Applicant response to POS consultation

LPA REF: BN/84/20/PL

SITE: Land at Angels Nursery, Yapton Road, Barnham

PROPOSAL: Application for variation of Condition 2 (approved plans) imposed on planning permission BN/93/19/PL for the development of 95 dwellings and consequential changes to other conditions following commencement of development.

**ANGEL'S NURSERY, BARNHAM - PUBLIC OPEN SPACE PLAN**

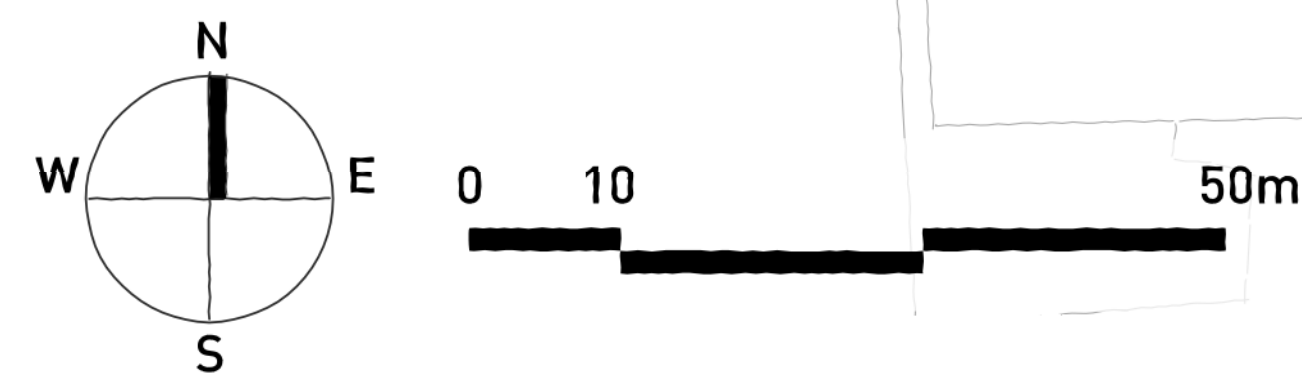
"Recommendation relating to this application re approved plans under BN/84/20/PL Greenspace would still uphold a Landscape objection to the quantity of POS being offered, albeit layout positioning not having changed significantly from the original application. The provision of SuDS areas and no clear detail of the nature of these and therefore the potential to further deplete the usable POS within this development would conclude that POS provision within the site does not meet out SPD requirements and therefore would have to be recommended as a Greenspace objection."

12. The current application provides **0.53ha** (5,303 sqm). This would be a similar arrangement to the extant planning permission, but with an increase in POS of 34sqm.
13. The application site will provide 79% of the SPD requirement which exceeds what was achieved on both the extant scheme and adjacent Lillies site.

14. Unlike the extant permission the current proposal also provides the potential for a play area on-site.
15. The Applicant remains committed to providing financial contributions towards meeting any necessary off site POS improvements, as before.

20. The proposals include a quantum of POS which is no less than the extant permission. In fact, it includes more POS.
21. The LPA has previously confirmed that the location of the site adjacent to existing POS means that off site contributions are appropriate. Nothing has changed in this regard
